From: Bloomer, David <David.Bloomer@lancashire.gov.uk>
Sent: 10 September 2018 10:24
To: Robert Major
Cc: LHS Customer Service; planning
Subject: app3/2018/0700 Lower Gazegill Farm, Rimington

the proposed development will involve the erection of a stand-alone unit for the purpose of food sales and deli plus 2 3 bed holiday let units.

Proposed Site Plan - 1:500

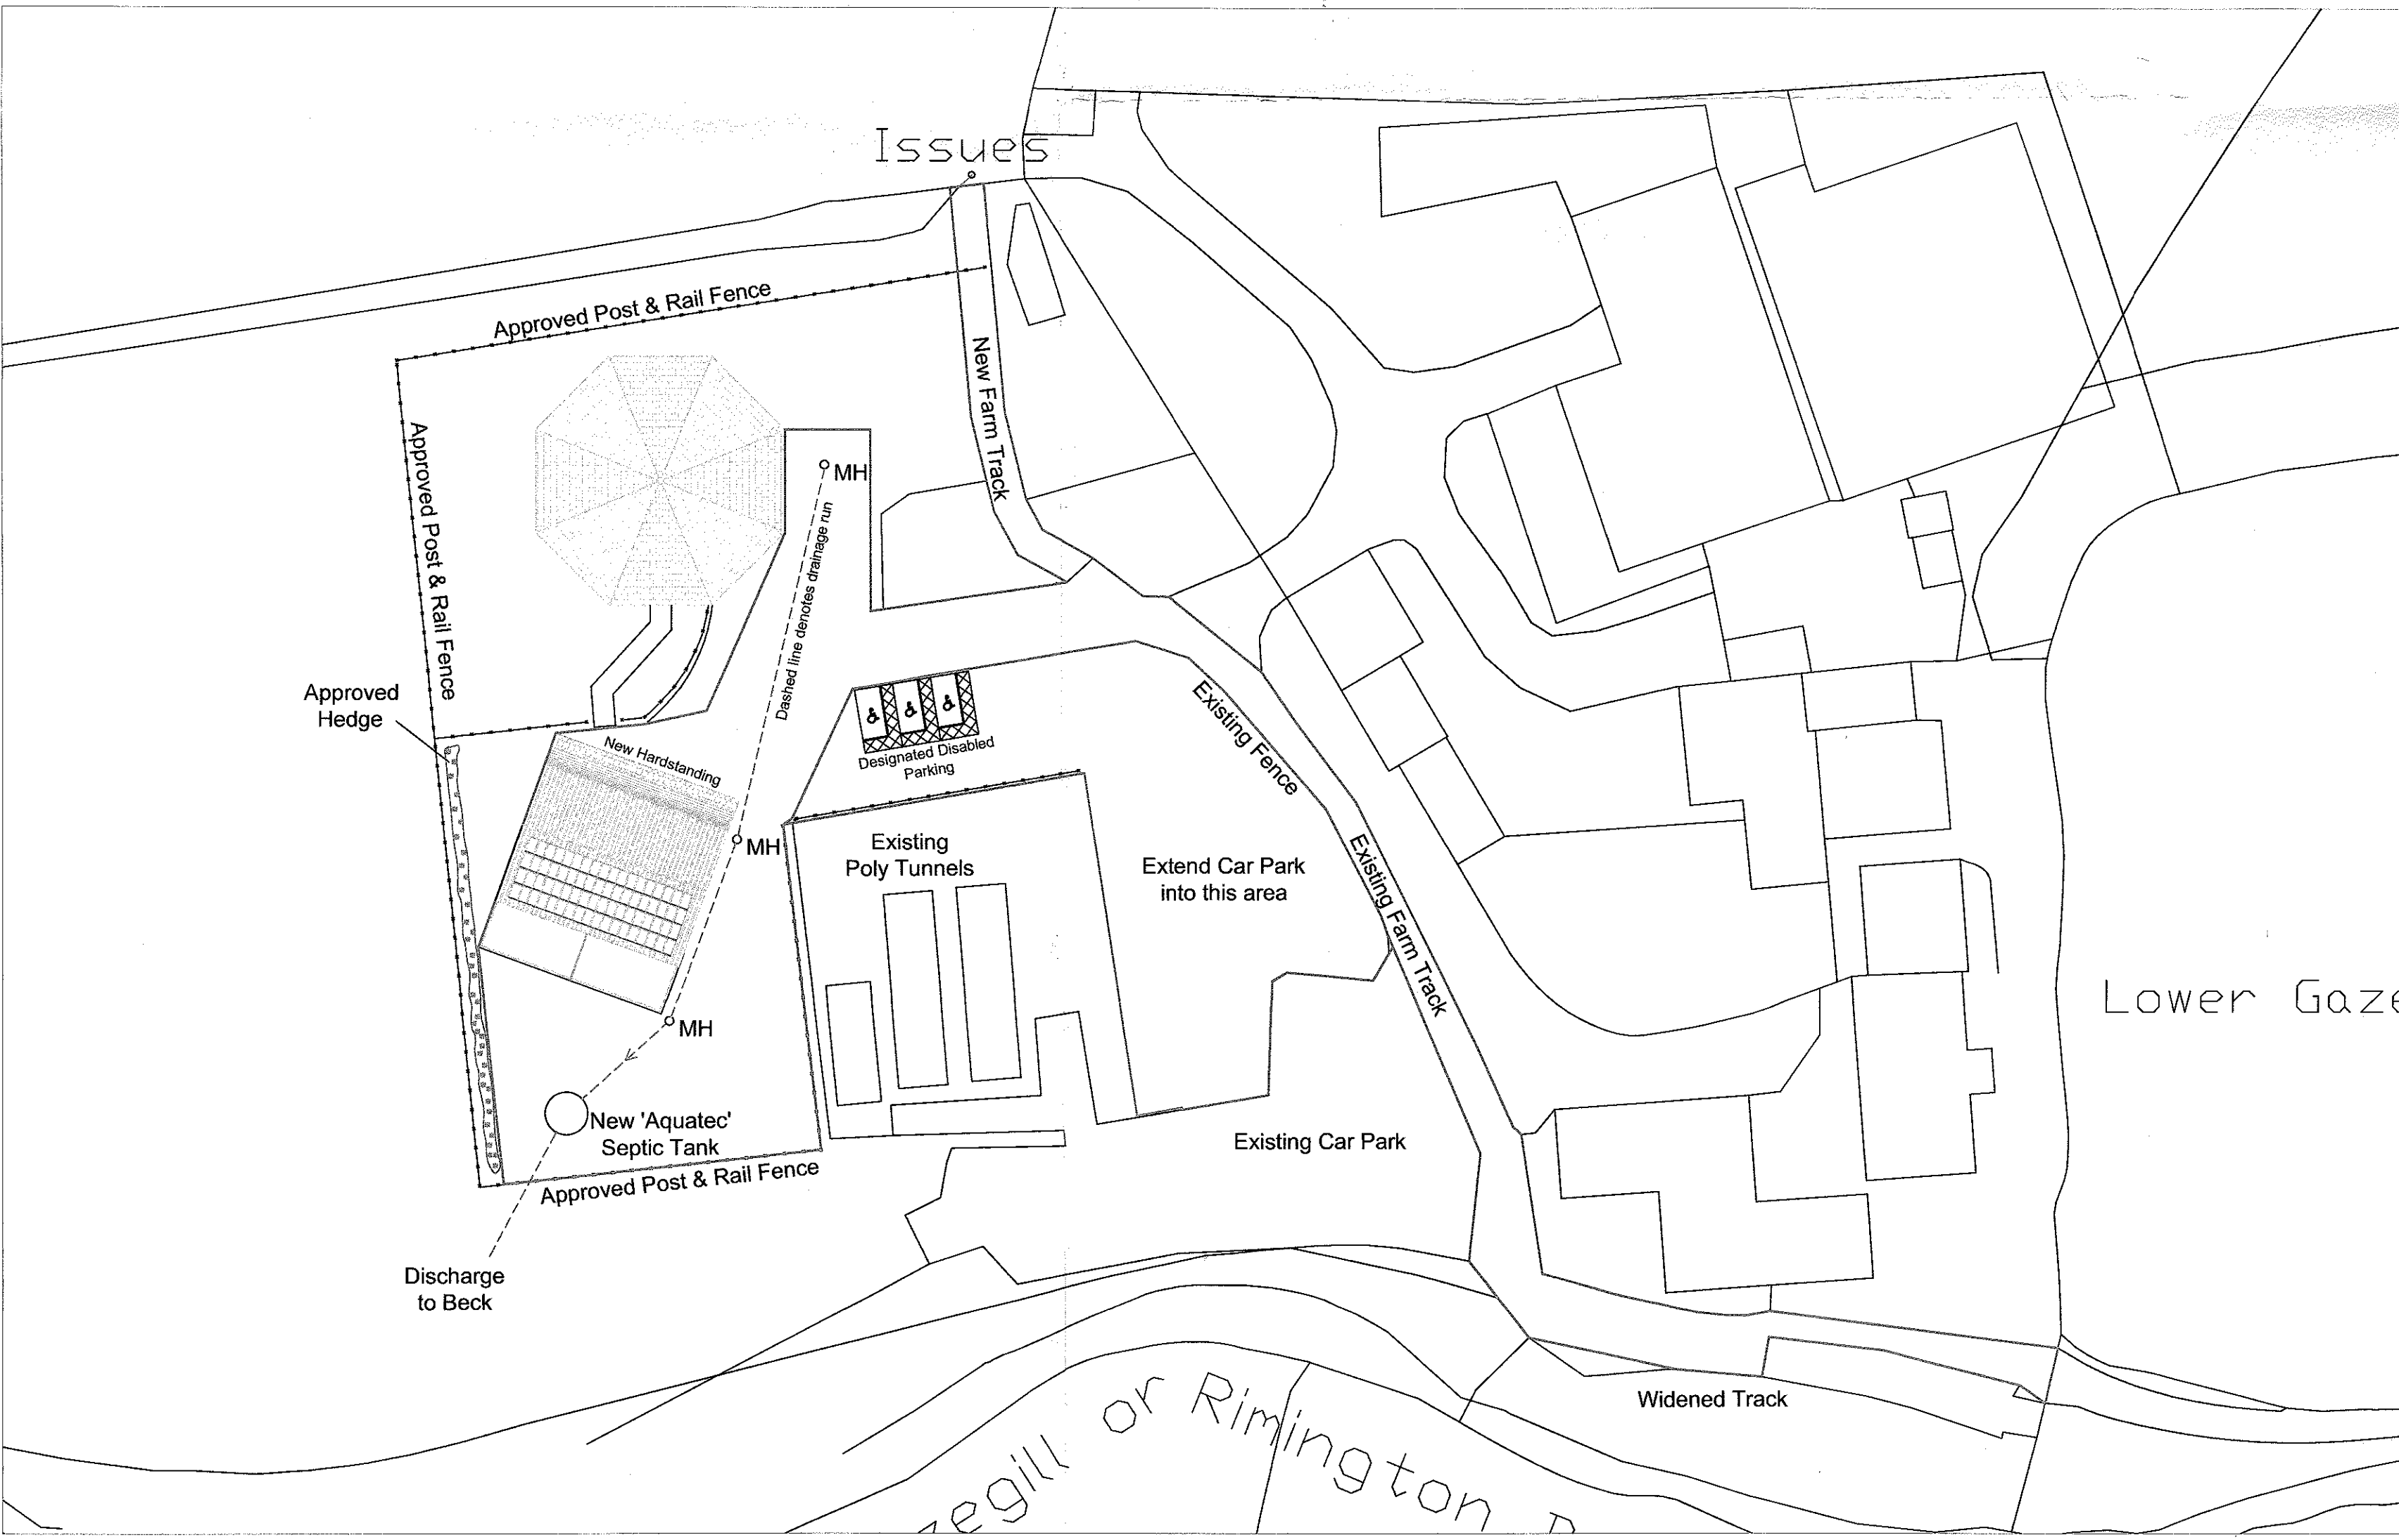
In the previous highway consultation response to application 2016/1159 for the erection of a farm tea room, concern was expressed regarding increased vehicle movements on Dancer Lane (privately maintained single track road) which has limited passing places and is the route of a public right of way. The highway recommendation was that permission should only be granted if passing places were provided along Dancer Lane. Having visited the site I am not aware that the situation regarding the provision of passing places has changed in the intervening period. The planning permission granted for the 2016 application does not make reference to the need for passing places but I am not sure if their provision is included on the amended plans referred to in the permission (these are not on the website)

On the basis of the information available I would have to re-iterate the highway authority's concerns regarding the safety of the access to vehicular and pedestrian users and the potential of the retail facility afforded by the proposal increasing footfall to the site such that I would have to recommend that the application be refused on highway safety grounds.
